APPLICATION CONSULTATION RESPONSE

Application Number:	3/2018/0914
Location:	Land off Clitheroe Road Whalley (Lawsonsteads phase 2) BB7 9RG
Proposal:	Erection of 188 new dwellings including means of access and associated works. To include 57 affordable dwellings (29 affordable rent and 28 shared ownership).

Drawing Number
D0101

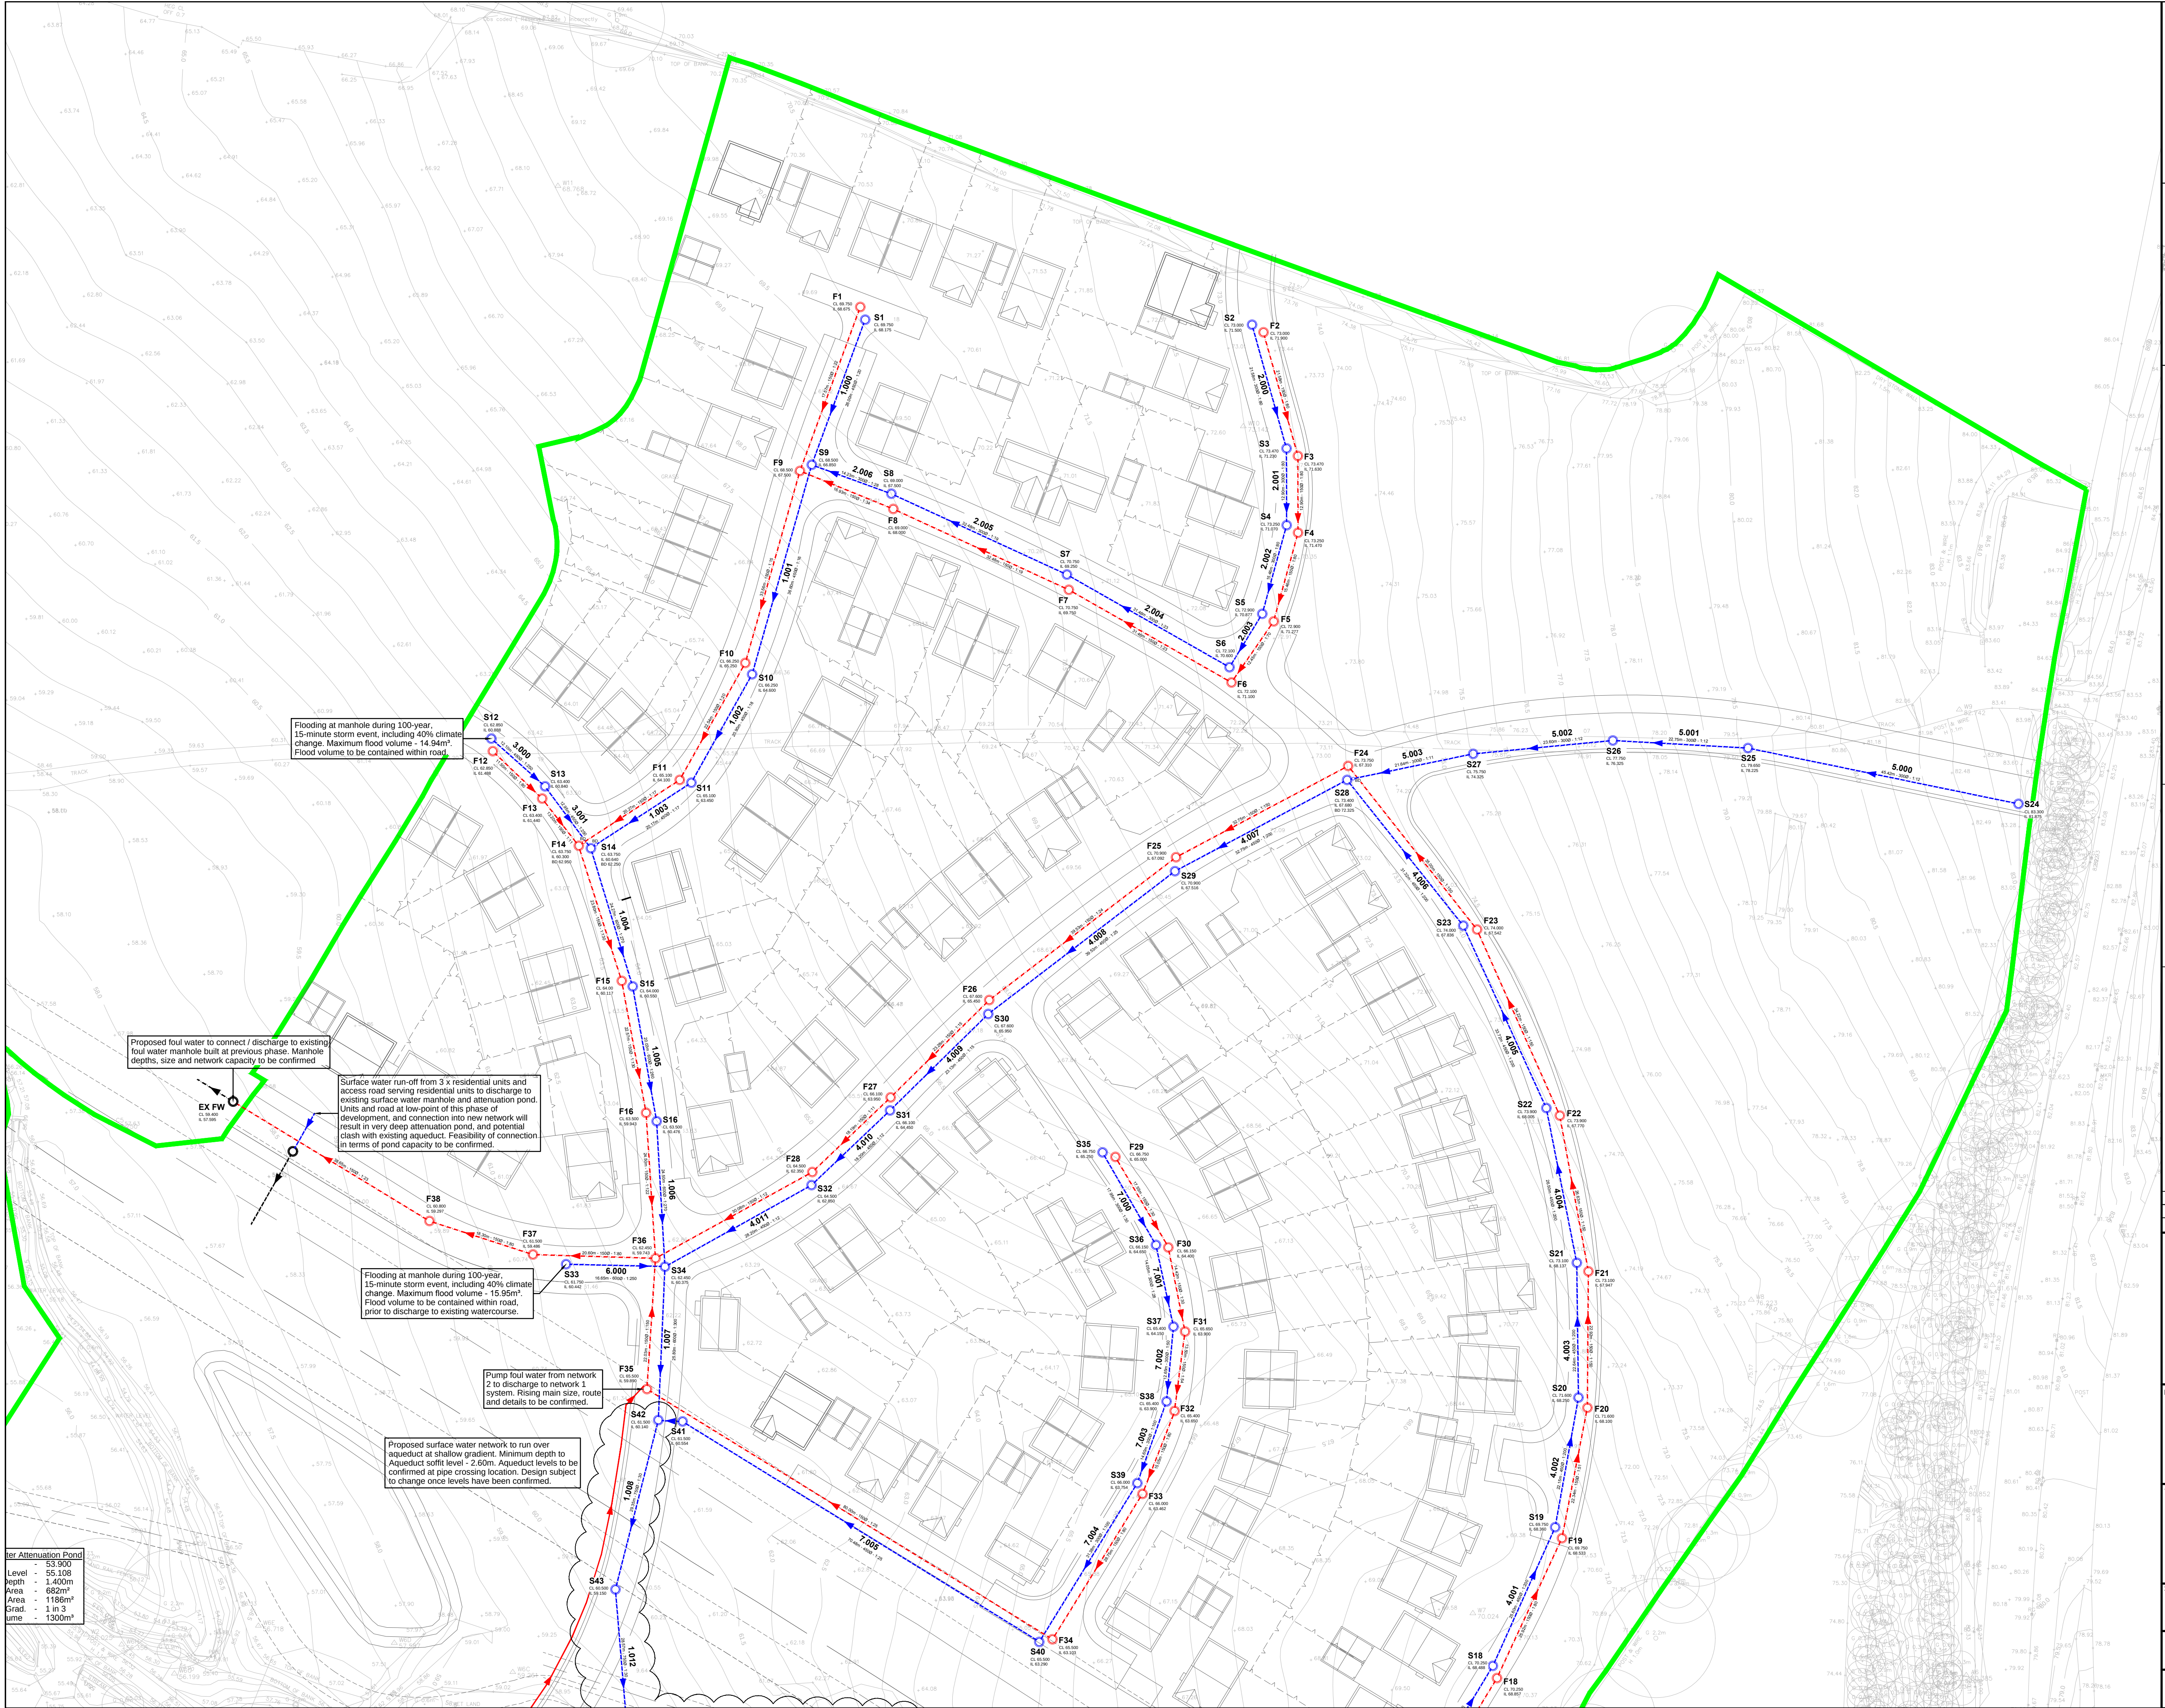
The LLFA understands that the surface water drainage scheme outlined on drawing nos. D0101 Rev P6 and D0102 Rev P5 is only a preliminary issue and may be subject to change following detailed design and investigation. For example, changes may still need to be made to the design and operation of parts of the proposed

drainage network, depending on the applicant's final review of the northern attenuation pond design (see the annotations provided). As the submitted plans are still subject to change, the plans cannot be considered for approval at this time. The applicant will instead need to provide the final details once the detailed design and investigation work has been completed. The final plans will need to be submitted to and approved by the LPA prior to the commencement of any development, and must comply with the requirements of the National Planning Policy Framework and the non-statutory technical standards for sustainable drainage systems; March 2015. The LLFA is satisfied that the final drainage details can be secured through the inclusion of the above recommended planning condition.

No development shall commence until final details of the design, based on sustainable drainage principles, and implementation of an appropriate surface water sustainable drainage scheme have been submitted to and approved in writing by the local planning authority. Those details shall include, as a minimum:

- a) Information about the lifetime of the development, design storm period and intensity, temporary surface water storage facilities, details of the methods employed to delay and control surface water discharged from the site, details of any measures taken to prevent flooding and pollution of the receiving groundwater and/or surface waters, including watercourses, and details of flood levels in AOD;

- b) The drainage strategy should demonstrate that post development surface water run-off from the application site will not exceed a maximum rate of 57.7;/s. The scheme shall subsequently be implemented in accordance with the approved details before the development is completed;

- c) A site layout plan showing flood water exceedance routes, both on and off site;
- d) A timetable for implementation, including phasing as applicable;
